ADC PARKS & GREENSPACE ARBORICULTURE

PLANNING APPLICATION: EG/98/14/PL

ADDRESS: Rear of 59 Elm Grove Barnham PO22 0HJ

BRIEF DESCRIPTION: Construction of 3 No. two storey detached houses with new access.

Tree Constraints Plan

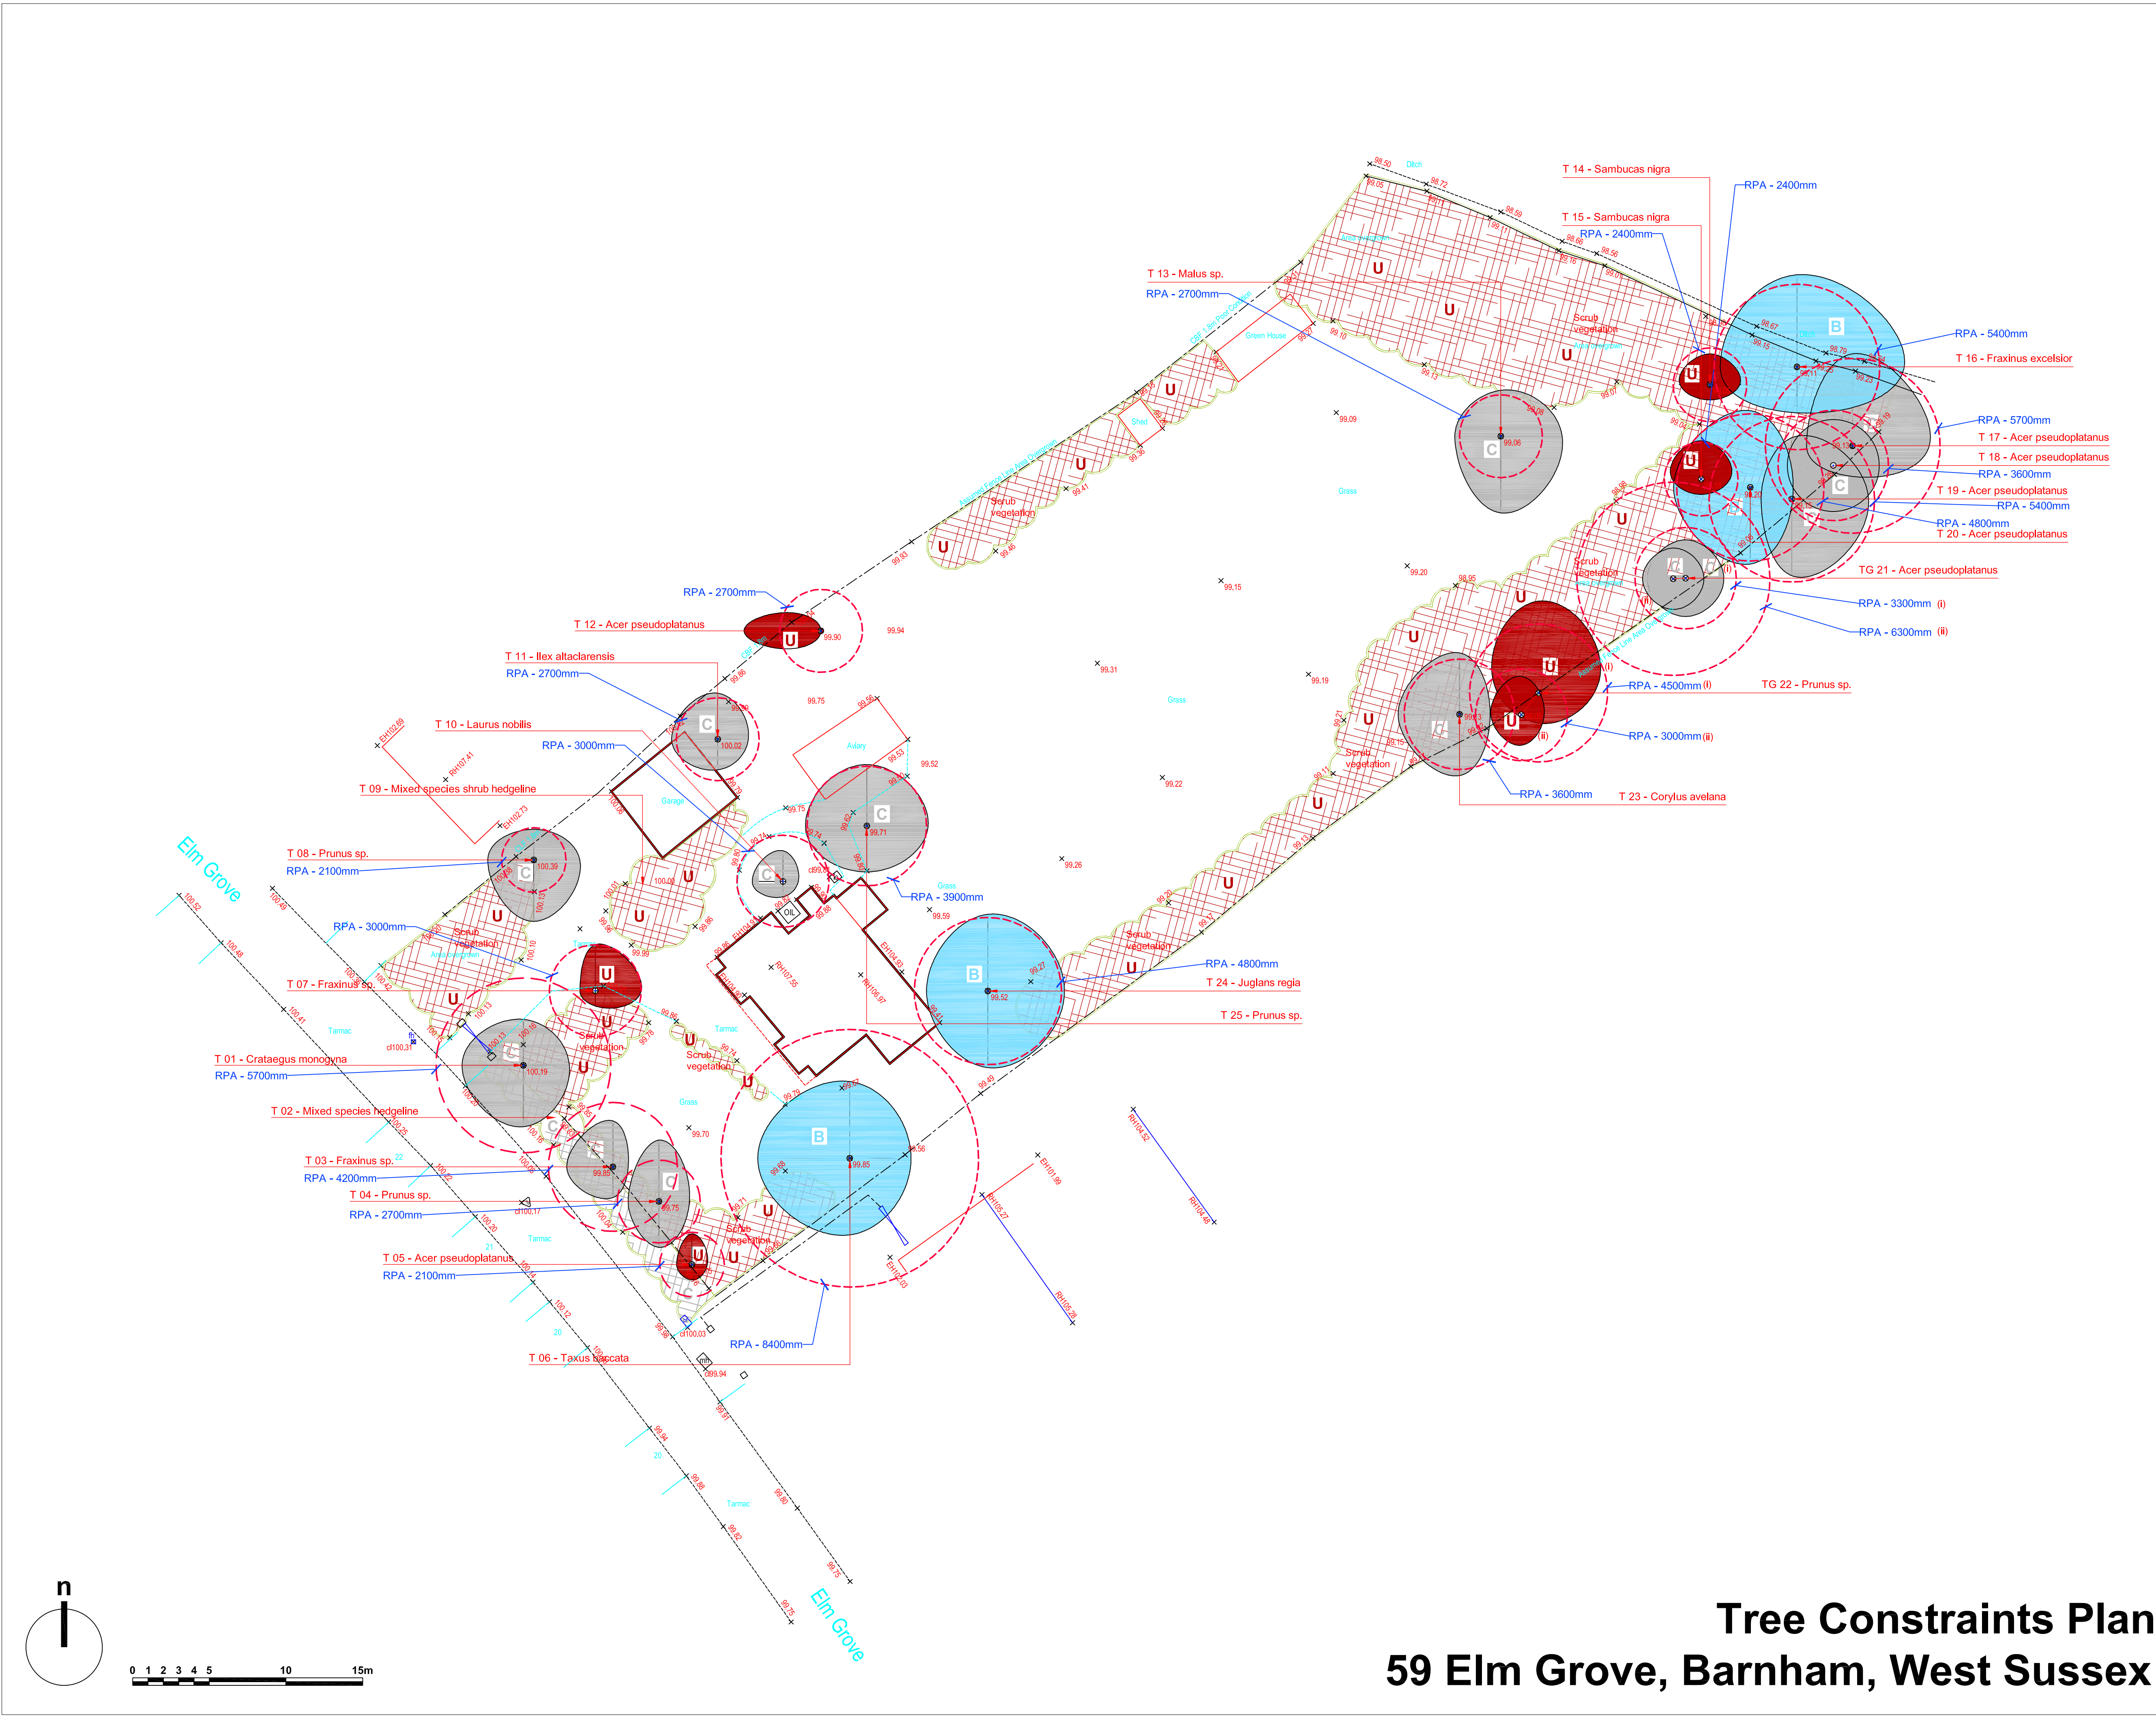
- The applicant has cited the desire to fell and remove **T5, T7, H9, T11, T12, T13, T14/T15, and TG 22**. All these trees have been characterised as 'U' (apart from **T11**), on the arboricultural assessment. I would agree with this assessment. As for **T11**, the applicant has assessed this tree as C1. I would also agree with this assessment, and would have no objection to the felling of this tree (as it is not suitable for a TPO order).

- The trees **T2, T3, T4, T6, T8, T10, T16, T18, T19, T20, T23, and T24**, are to be protected by static fencing that would section off the given Root protection areas. This ground protection offered by the applicant does meet the meet BS 5837:2012 Trees in relation to design, demolition and construction – Recommendations.

- For the trees **T1** and **T25**, the construction process is due to overlap the RPA's. The applicant has cited the use of no dig permeable paving within the RPA's that overlap with the construction process of trees **T1** and **T25**. Again this protection/mitigation would meet the standards of the BS 5837:2012 Trees in relation to design, demolition and construction – Recommendations.

- As I would have no objections to the retention/removal and arboricultural assessment submitted. Also the submitted protection and mitigation statements/plans would meet the criteria set by the BS 5837:2012. **I therefore have no objection to this application**, as long as the methodology provided is adhered to.
